An
Coimisiún
Pleanála

Specialist Report to Inspector

ABP-322069-25

Proposed development of the Ballynalacken windfarm project located between the towns of Ballyragget and Castlecomer in North Kilkenny.

Project: Ballynalacken Windfarm	
Drawing Title: Bridge at W3 - Option 1	
Drawing Number: BWF-39	
Sheet Size: A1	Scale: as shown
Drawn by: Conor Brett	Date produced: 24 February 2025

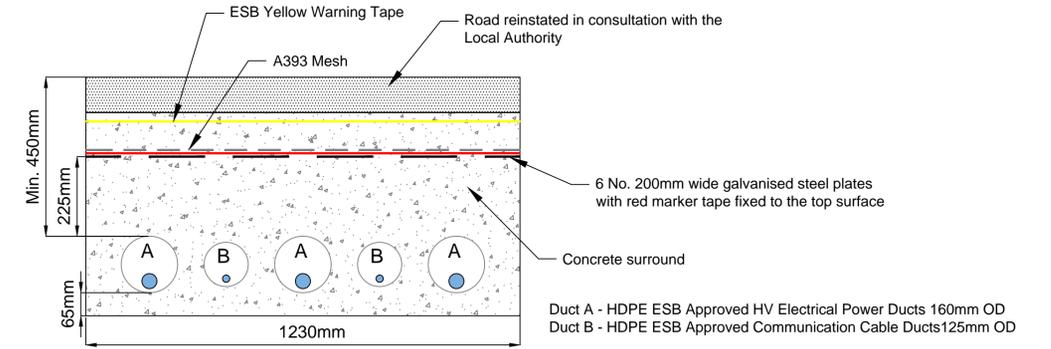
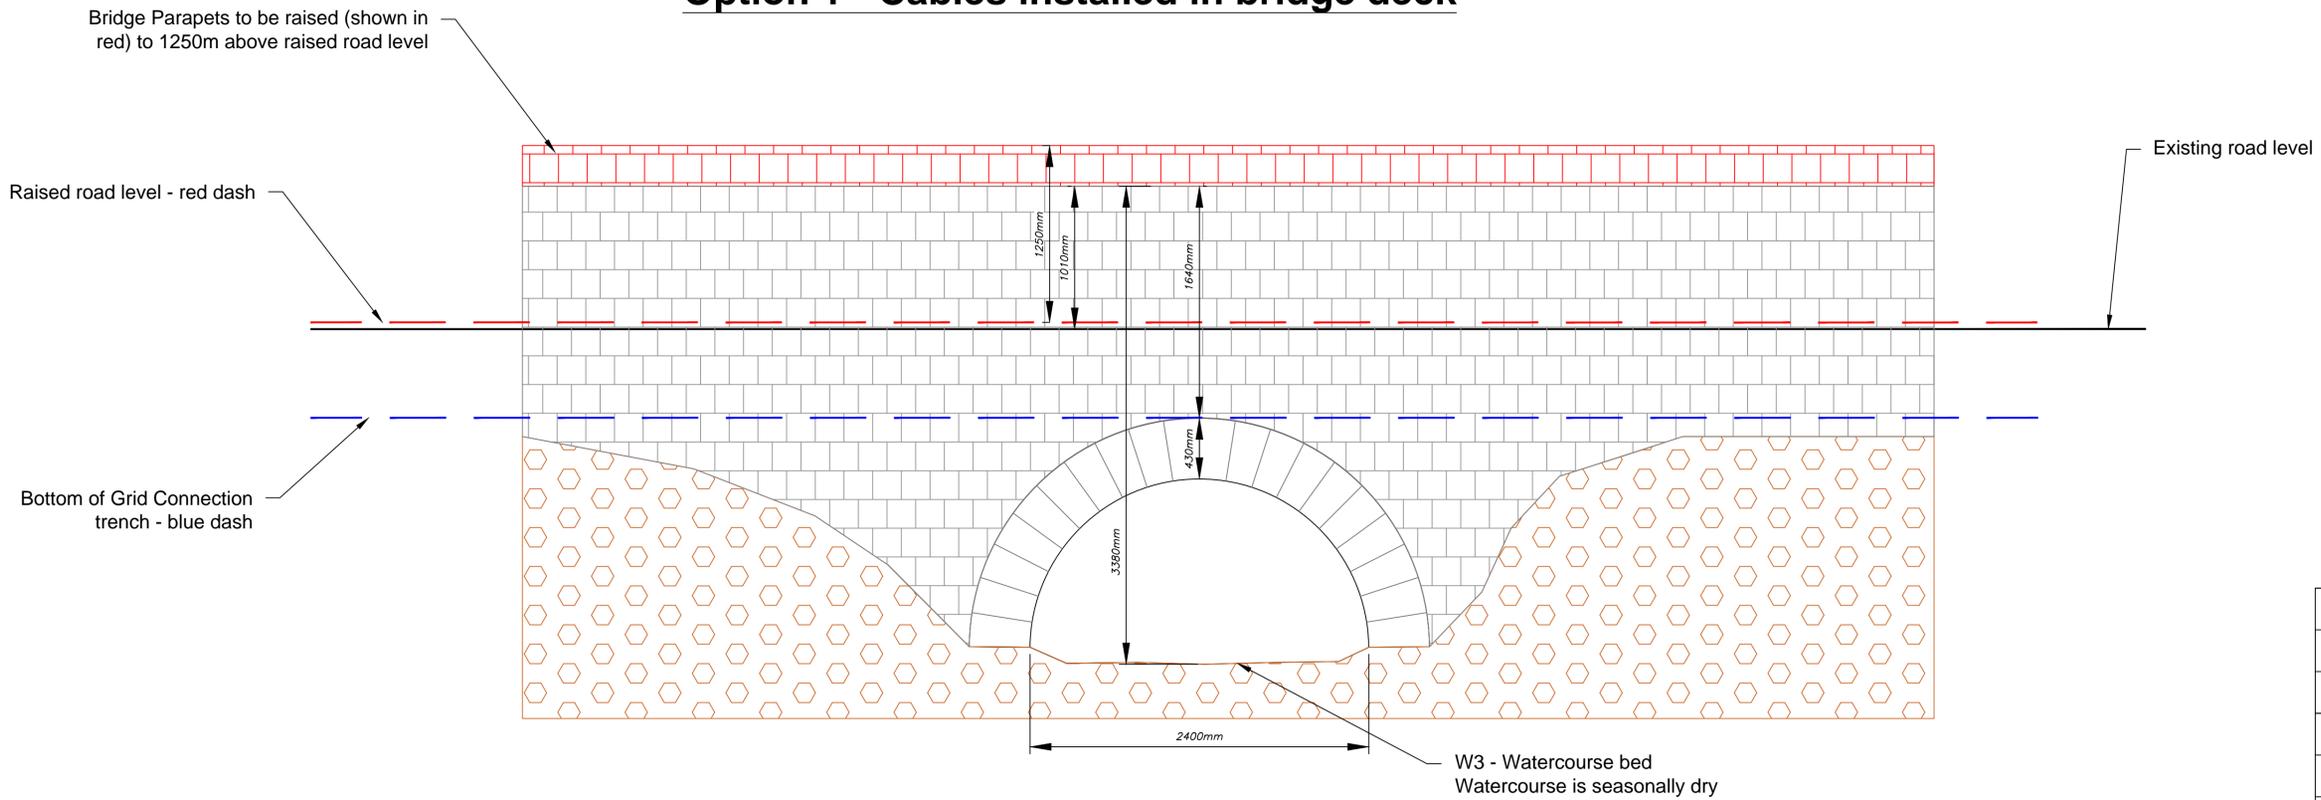
- 3.4.3. Of particular note to aquatic QIs of the River Barrow and River Nore SAC (including otter) and Kingfisher (QI for River Nore SPA) is the watercourse crossing No 3 (W3) for grid connection. W3 is located c.90m upstream of the SAC boundary (c80m as crow flies) and c180m upstream of the SPA boundary (c120m as crow flies). Two crossing options are proposed at W3 (option 1: through the bridge deck or option 2: underneath the bridge via horizontal directional drilling (HDD)). Instream works are

not required for either option at W3. I examine the potential impacts of the works at W3 further below in relation to otter and kingfisher.
